FULL

Reference:	H08-0852-25	Date of Decision:	6th November 2025
Applicant:	Mrs K M Baxter C/O Longstaff 5 New Road Spalding Lincolnshire PE11 1BS		
Location:	Belnie House Farm Buildings Belnie Lane Gosberton Spalding		
Description:	Demolition of Existing Barns & Erection of 2 Dwellings

4301-24 07 - Floor Plans Proposed & Elevations Proposed - Plot One

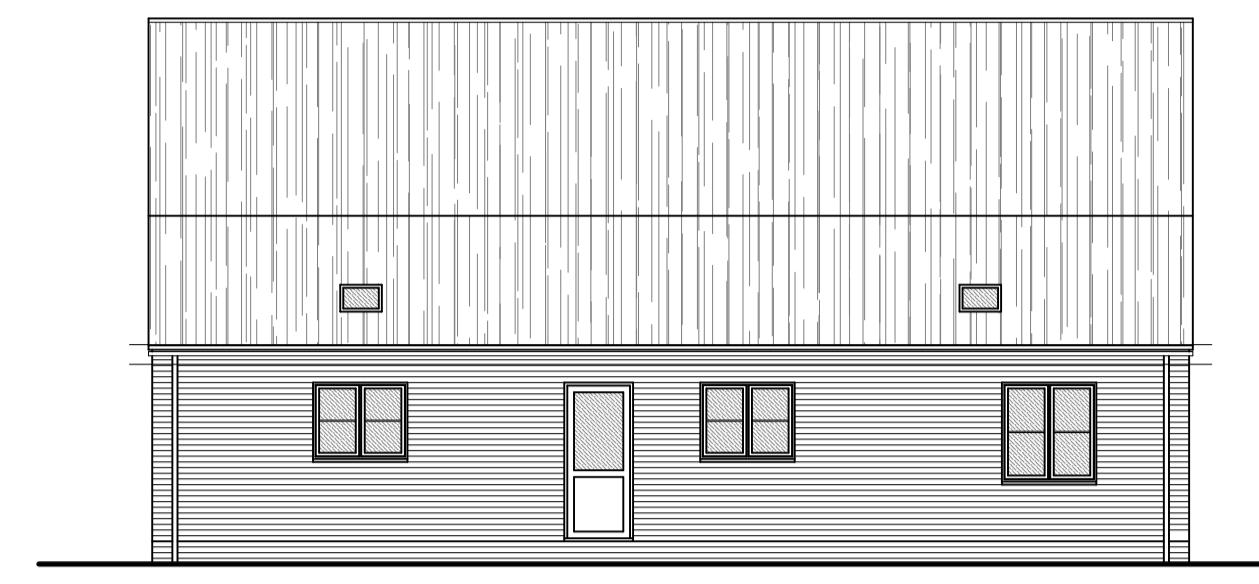
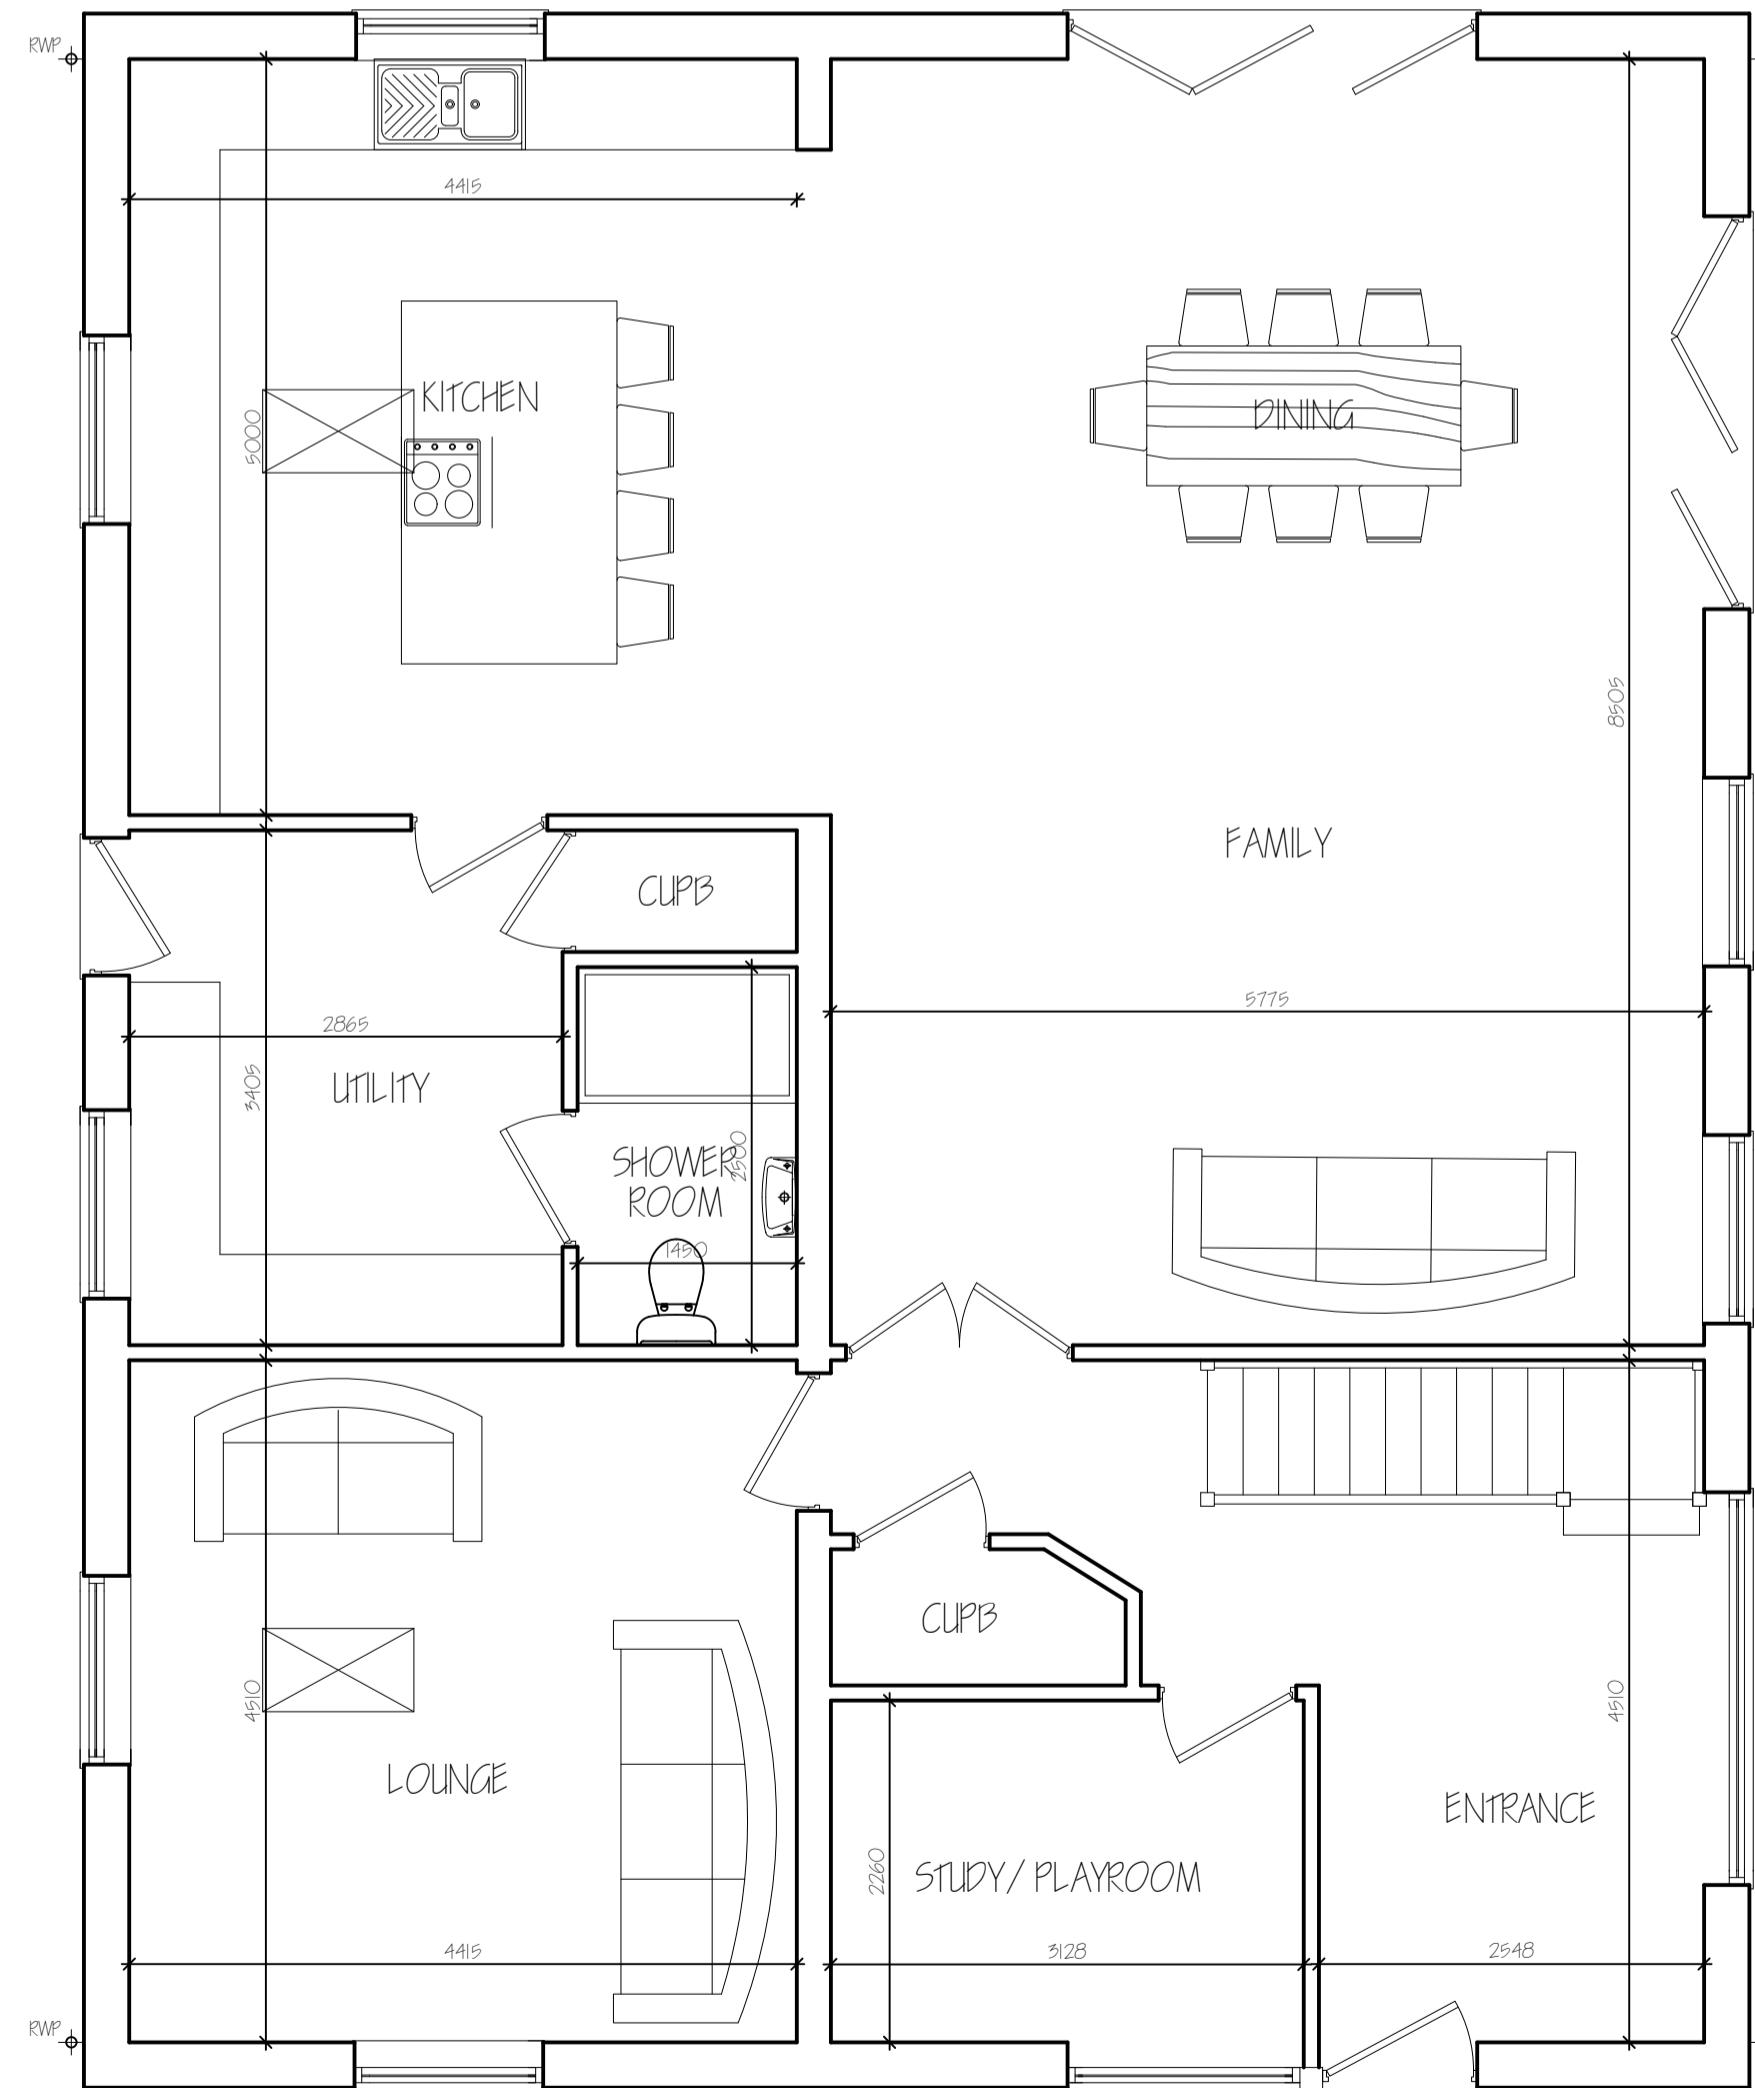
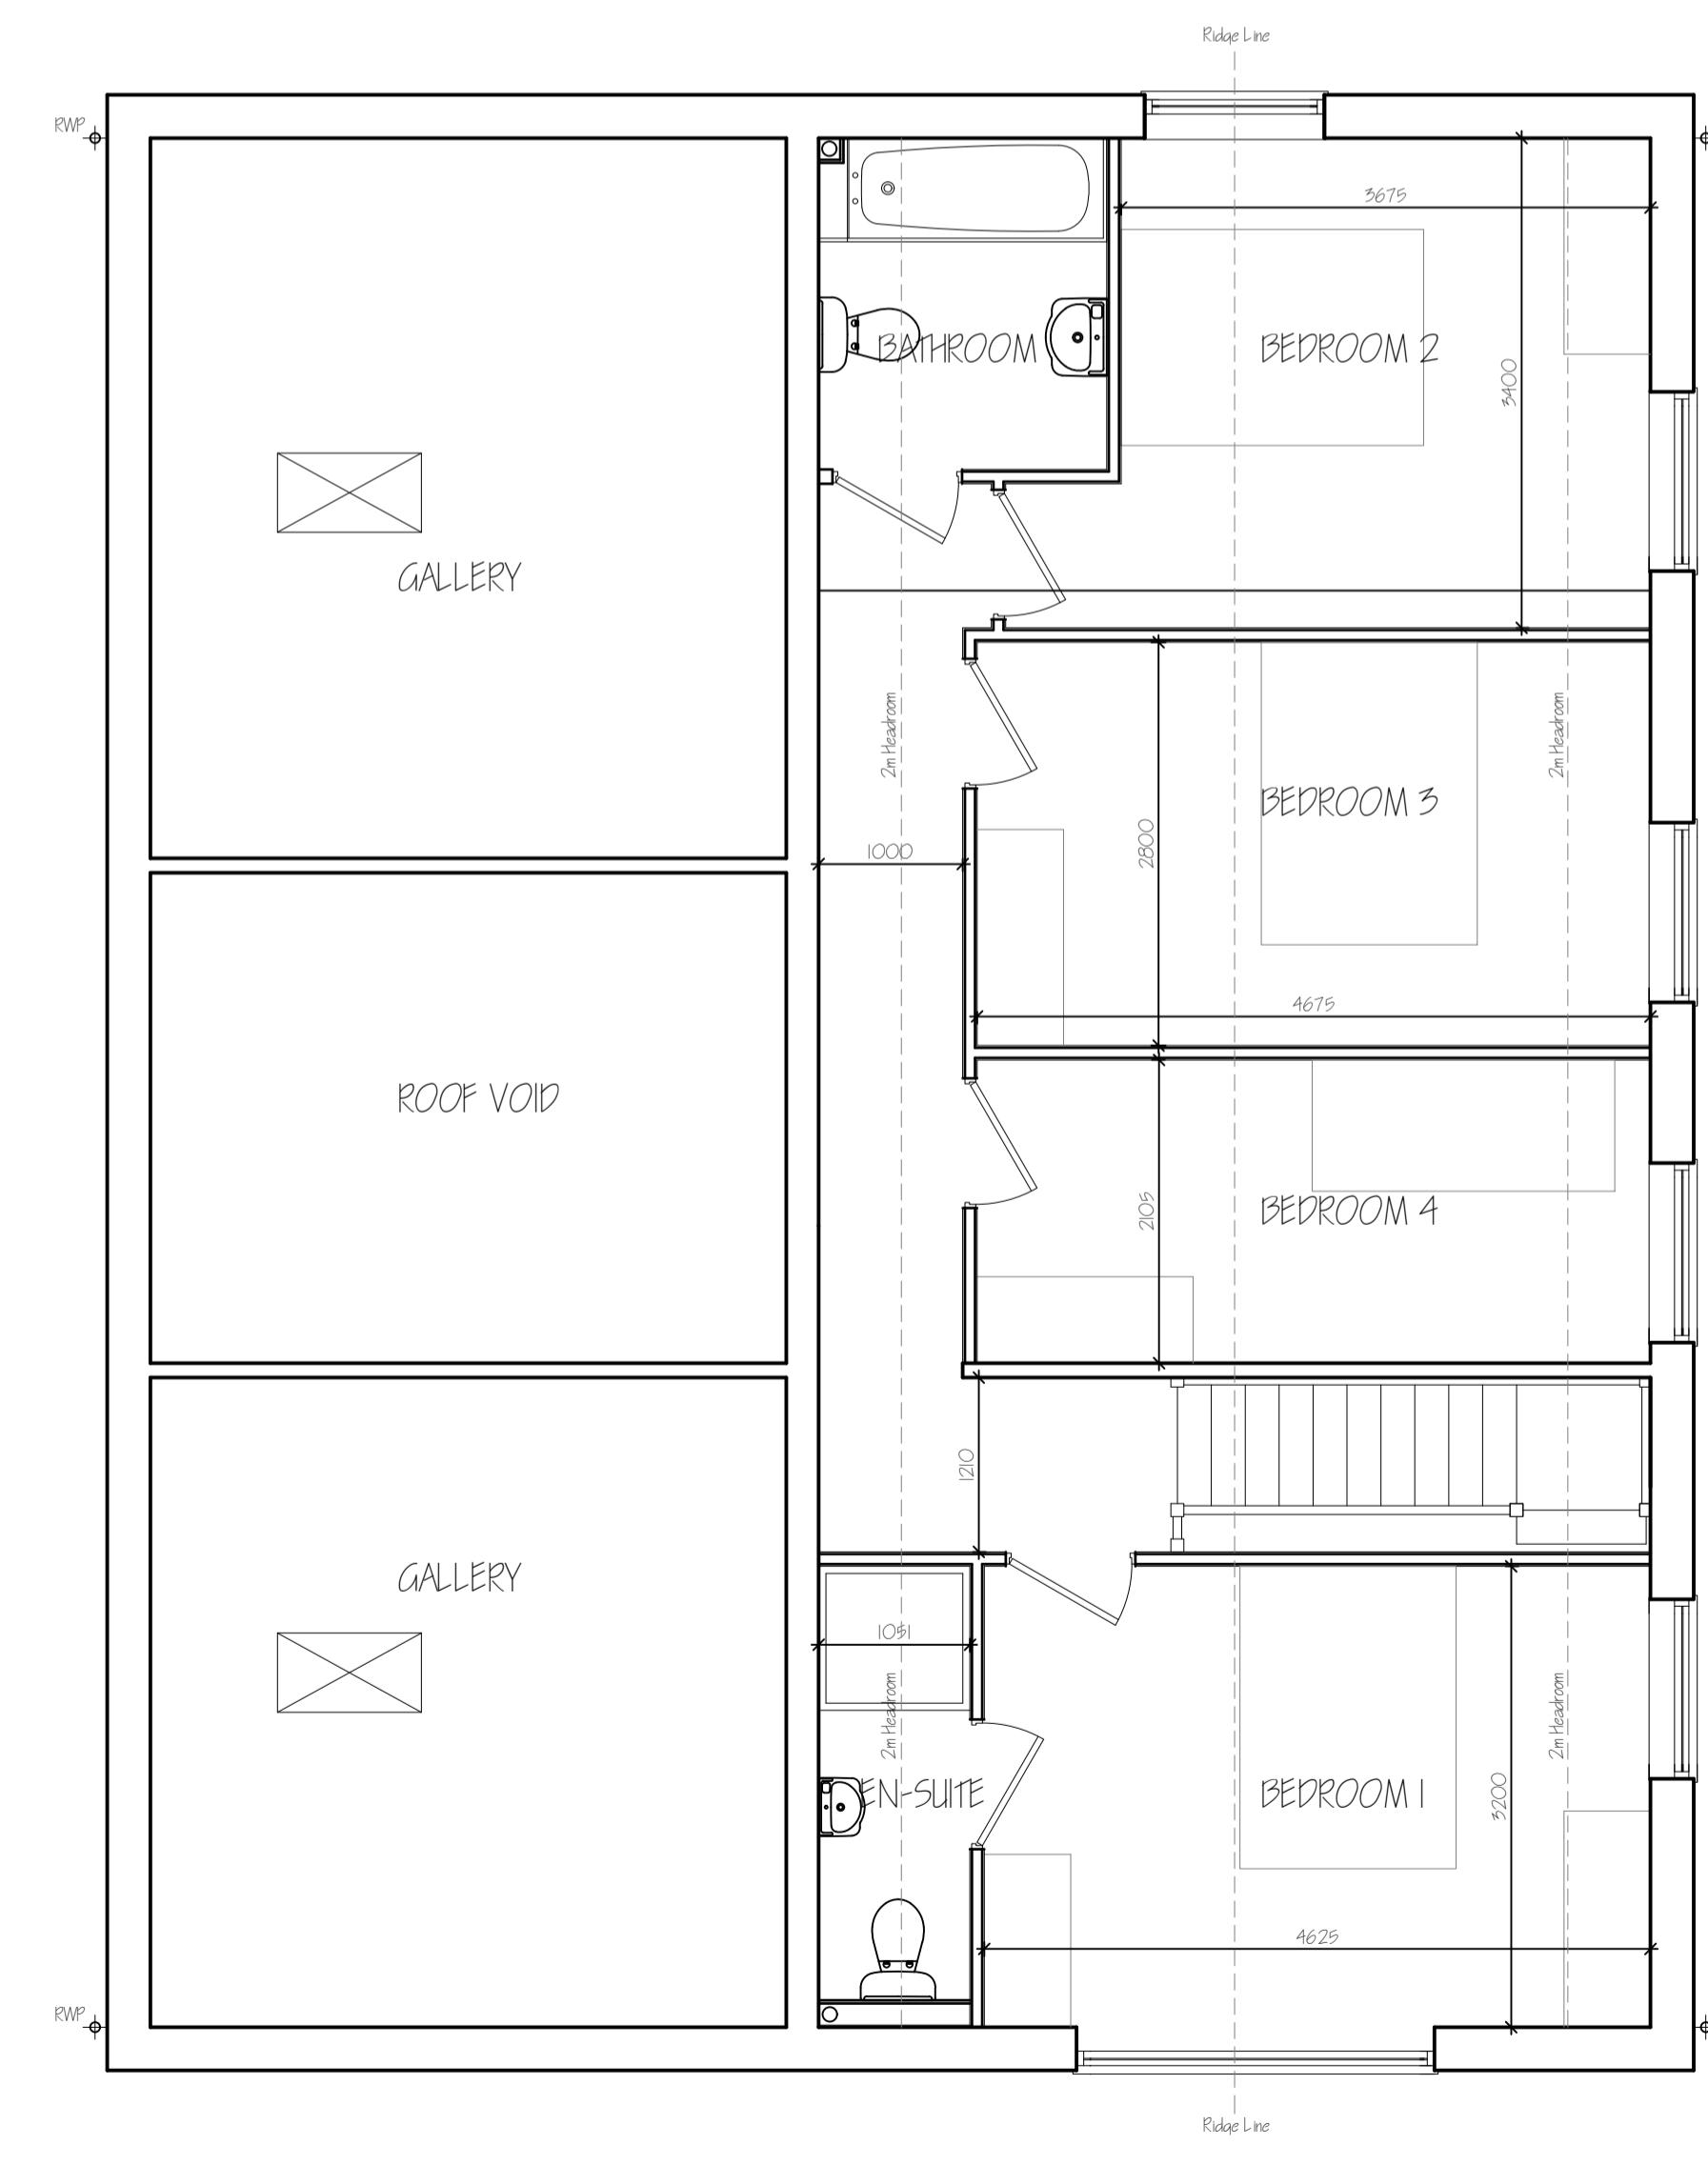
- 1 The proposed development is considered to be of limited architectural merit which would be at odds with the countryside context of the site. If approved, the development would have a more urbanising effect upon the area, than the development that has been approved under the prior approval consents within the site (H08-0970-24 and H08-0972-24). The proposal is not considered to represent betterment, over what has already been approved on this site and the proposal is considered to be contrary to the aims of Policies 2 and 3 of the South East Lincolnshire Local Plan, 2019 as well as Paragraph 187b of the National Planning Policy Framework, December 2024.
